Response to Planning Application

From: Arun District Council Greenspace

Application ref: A/268/21/PL

Description: Proposed car showroom and workshop with forecourt. This application is in CIL Zone (zero rated) as other development.

Drawing Title
Site Plan

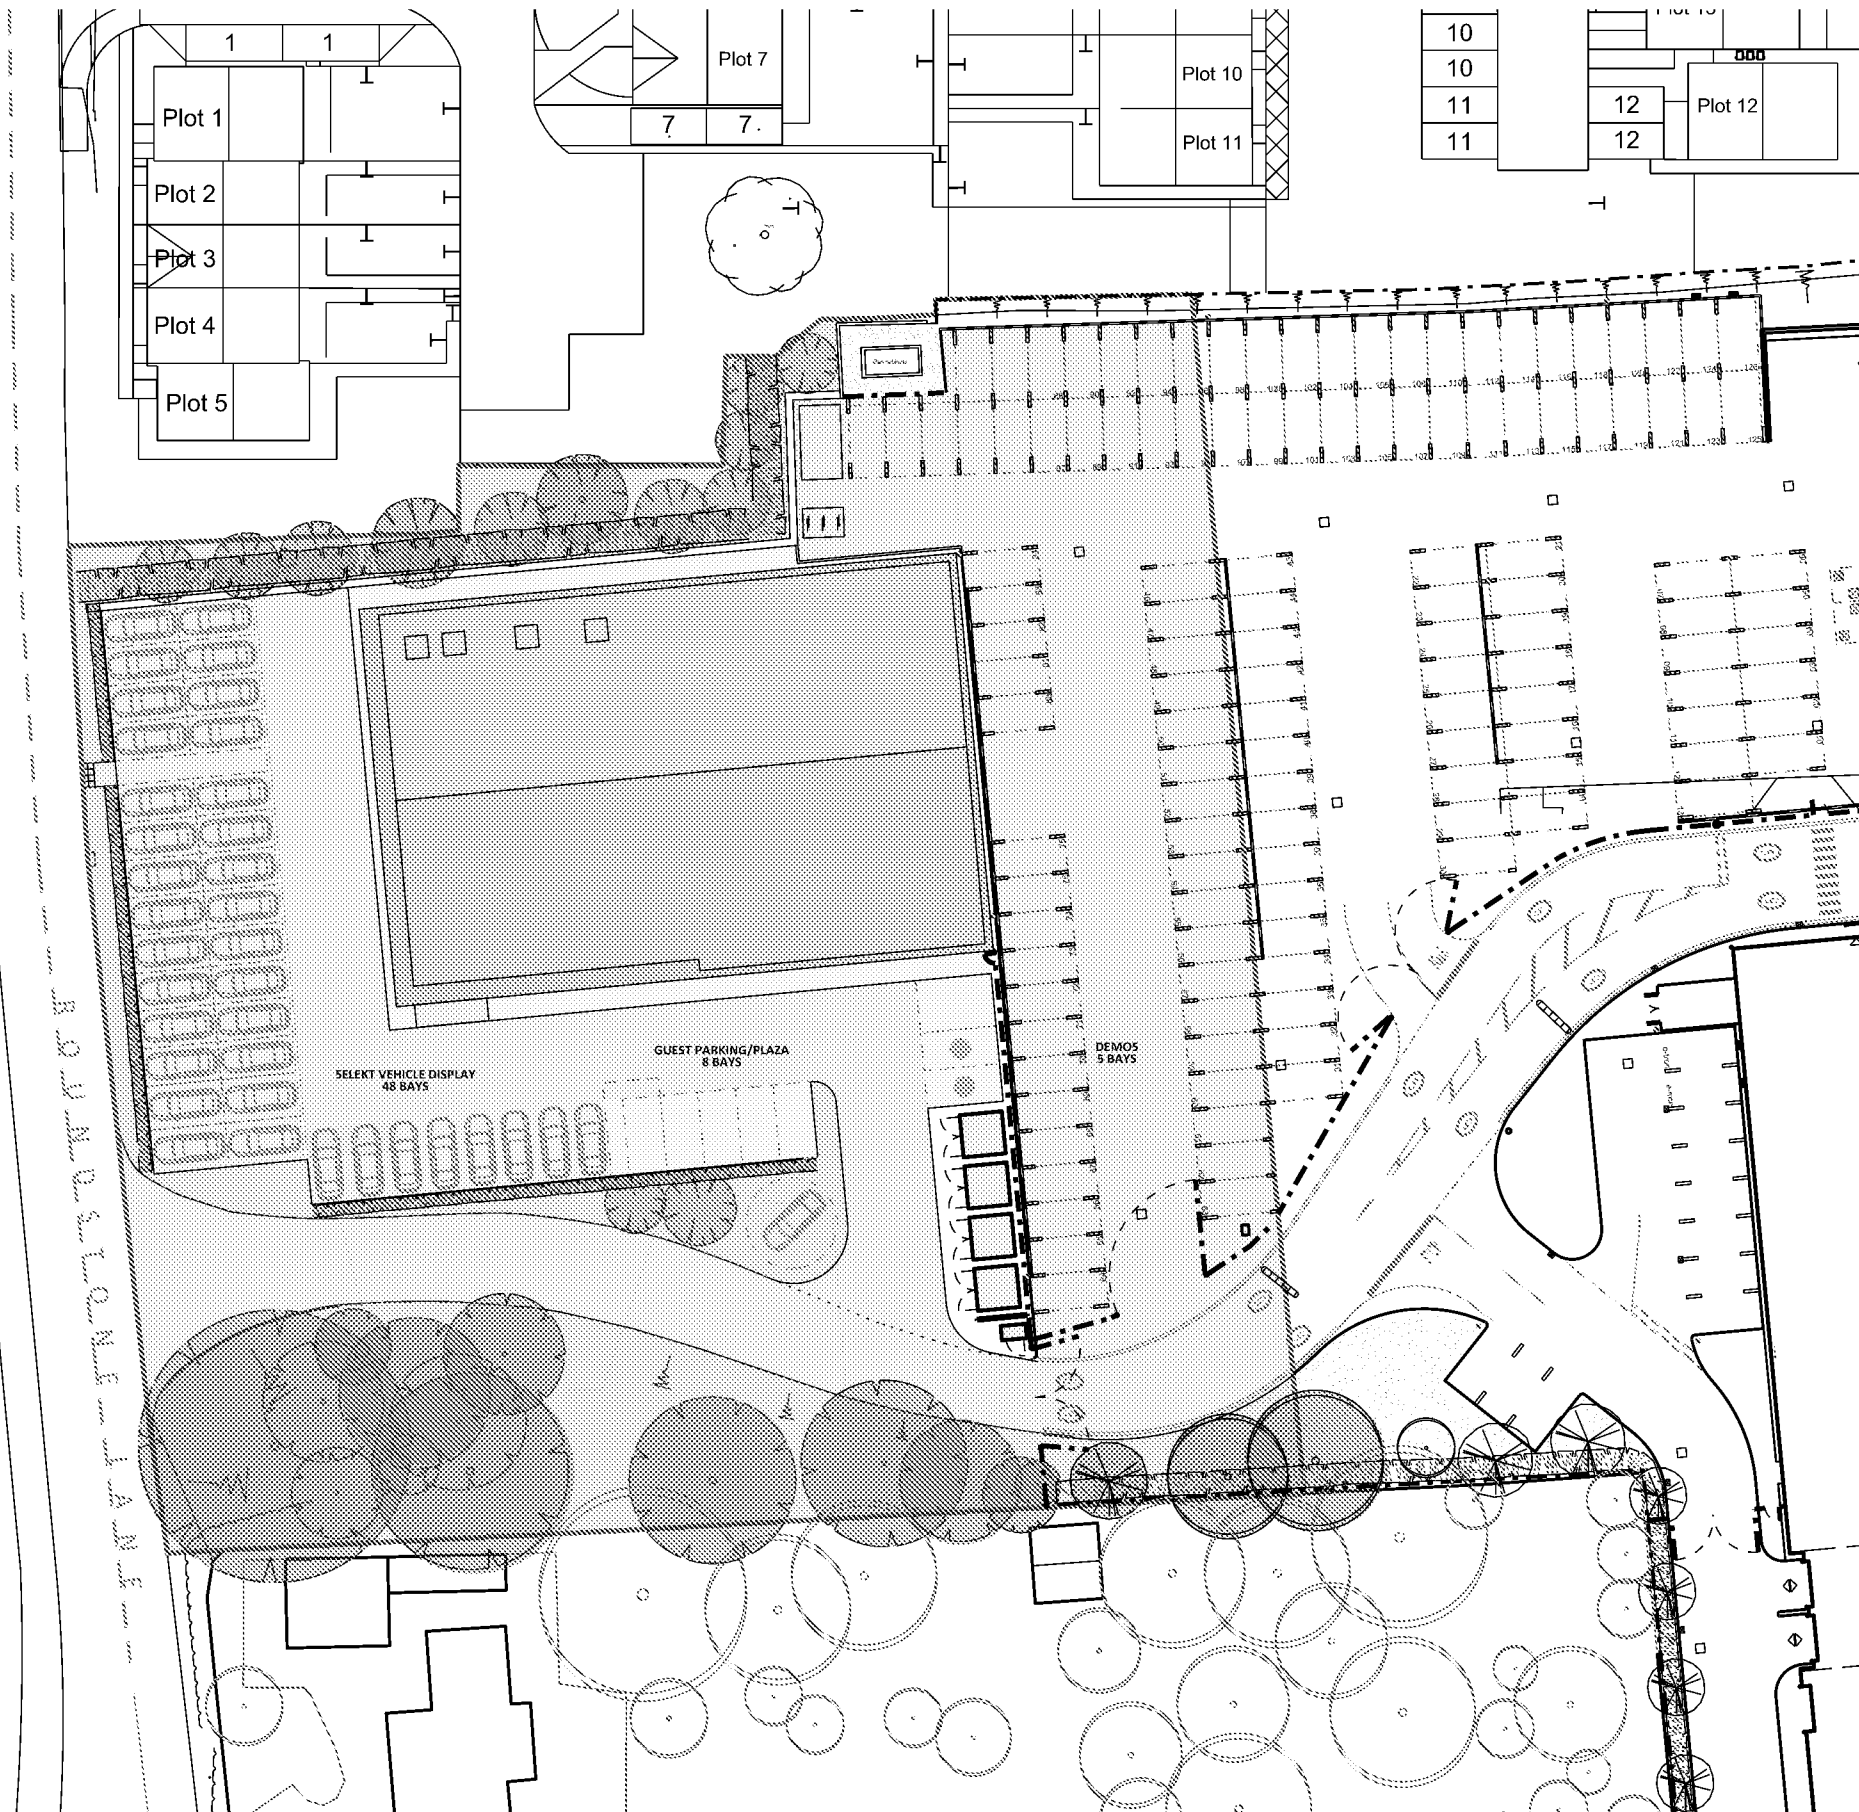
To the north of the site is a residential development known as Quiet Waters, there are dwellings which appear to share the boundary with the proposed development of which the development plans appear to differ from the curtilage of these plots. It has been indicated that there is an existing established buffer along this northern residential boundary which is not the case. Detailed landscape plans would need to be submitted to accurately show the proposed landscape offer along this and the other boundaries and the proposals within the site and indicate where screening mitigation may be required.

The indicative DAS landscape proposals state that *'adequate space has been provided along the northern boundary in order to create an enhanced landscaping strip. Structural landscaping will be added to complement the existing mature trees. The timber fence will be retained, with low level planting to add to the structural planting'* If approved landscape details would need to be submitted in the form of a detailed planting plan and specification detailing species choice, actual plant quantities, planting densities and size at time of planting. Detail should also be provided regarding existing trees and boundary planting. Soft landscaping would be required to offer some greening to the proposals in this location.

Landscaping would need to be provided, all proposed planting should consider the setting of these proposals and the neighbouring properties in this location. Trees, shrubs and ornamental planting would need to be specified at a size to allow instant impact, but which would establish and mature as the site develops.

Recommend no landscape objection to the details proposed in this application A/268/21/PL subject to submission of soft landscape details.
